CITY OF ALBUQUERQUE

RE: Lot 38 Block 8 Unit 22 Volcano Cliffs Subd. 6435 Picardia Pl NW Request for Permanent C.O. - Not Accepted

Engineers Stamp Date 5/18/16 (D10D003E38)

Certification Dated: 1/15/17

GRADING AND DRAINAGE PLAN
LOT 38 , BLOCK 8 , UNIT 22 , VCS
ADDRESS: 6435 Picardia, PL NW

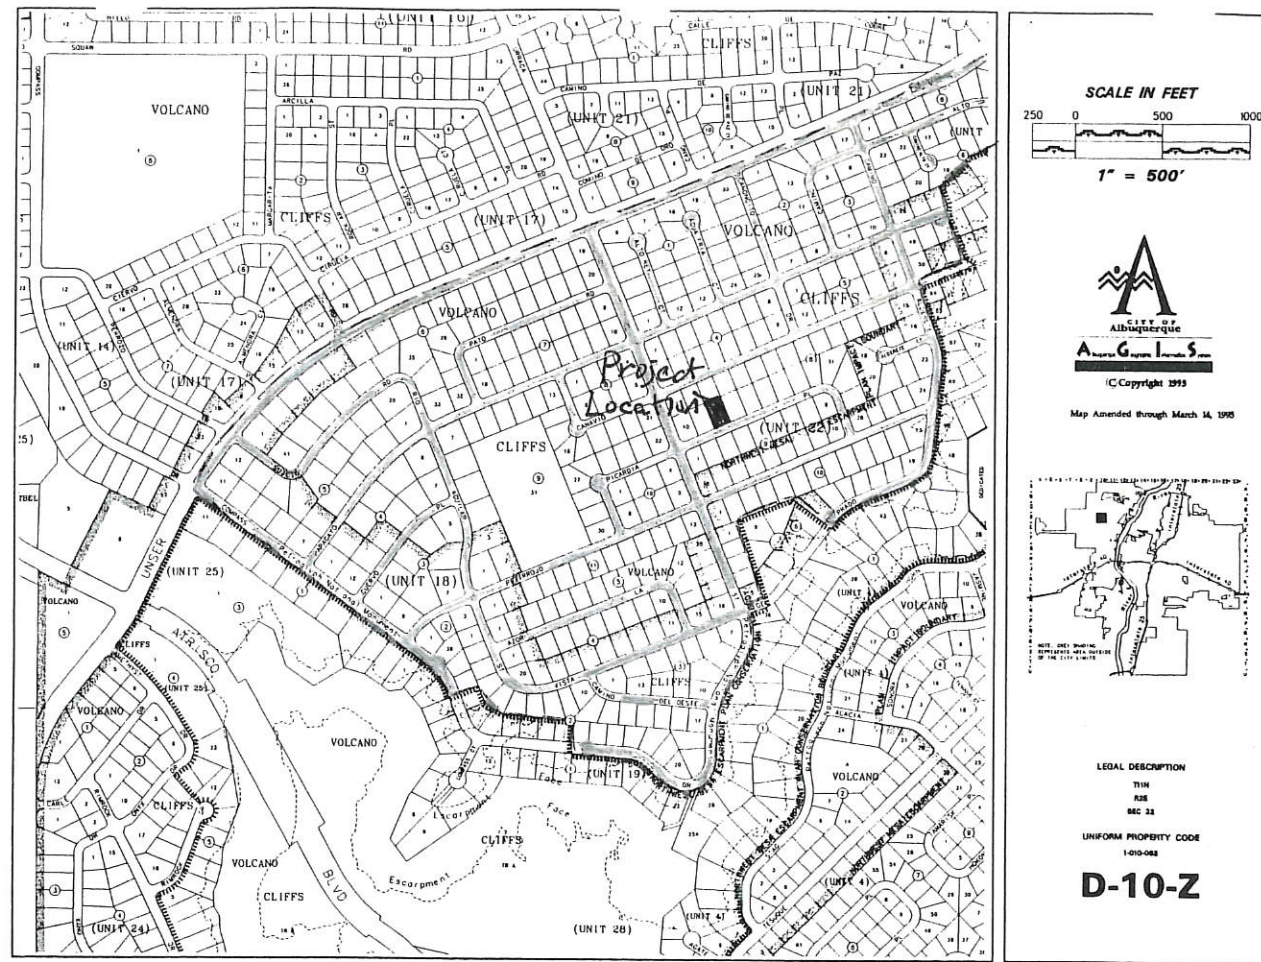
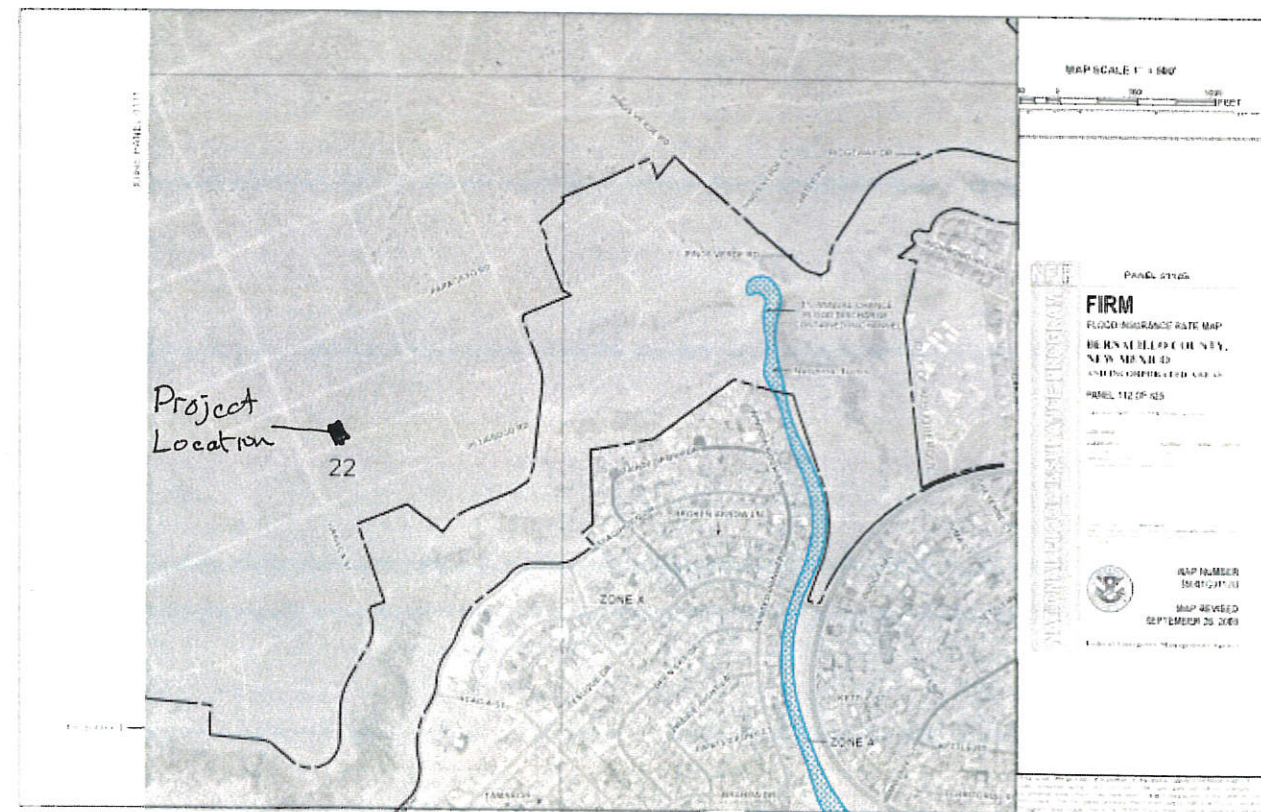
• The 8" x 12" opening in the backyard wall on the south side is missing. It must be added as indicated on the approved grading and drainage plan.
